Rezoning Transportation Analysis

Petition Number: 2023-037

Reviewer: Natalie King, PE
Natalie.King@charlottenc.gov
980-417-0206

Revision Log:	Date	Description
	7-26-23	First Review (IW)
	8-24-23	Second Review (NK)
	10-25-23	Third Review (NK)
	12-27-23	Fourth Review (NK)
	1-24-24	Fifth Review (NK)

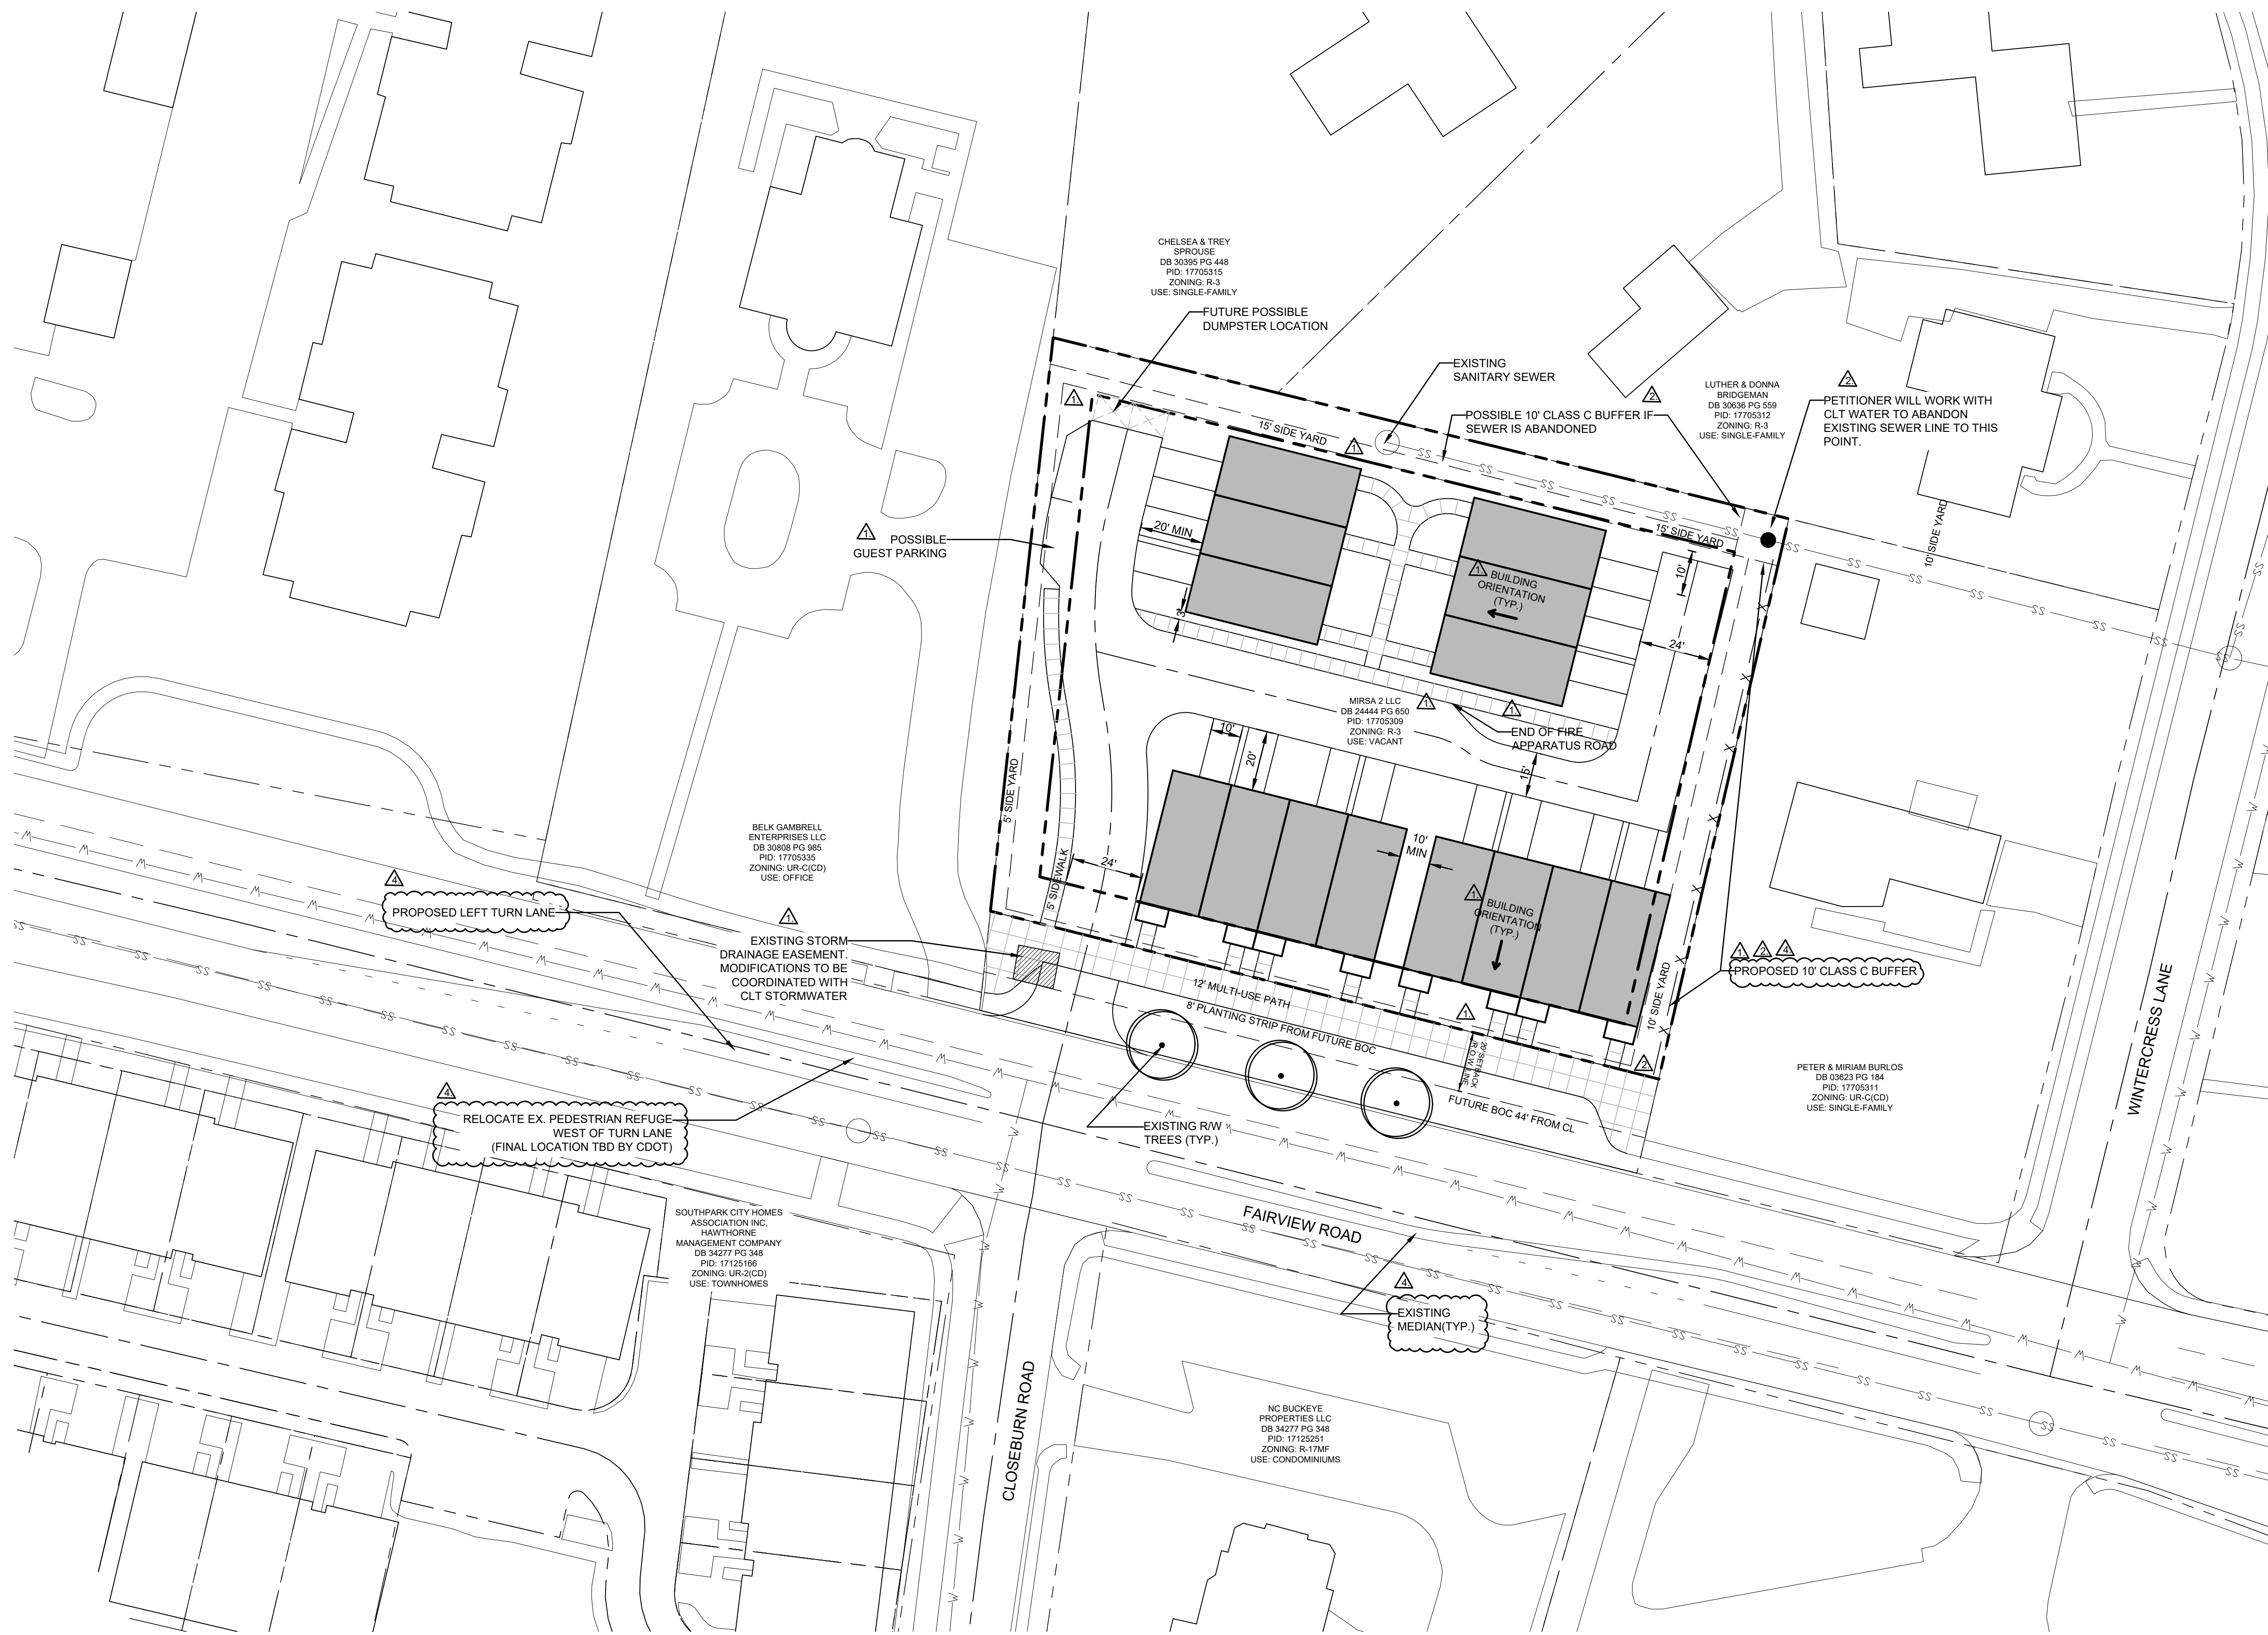
~~**Fairview Road:** Show future location of back of curb and gutter to be 44 feet from roadway centerline to accommodate the Charlotte Streets Map~~

~~NOTE: Additional distance from center line to back of curb may be required in locations where a median is present or around intersections and interchanges.~~

~~Label and dimension the curb and gutter from the centerline for each road on the site plan.~~
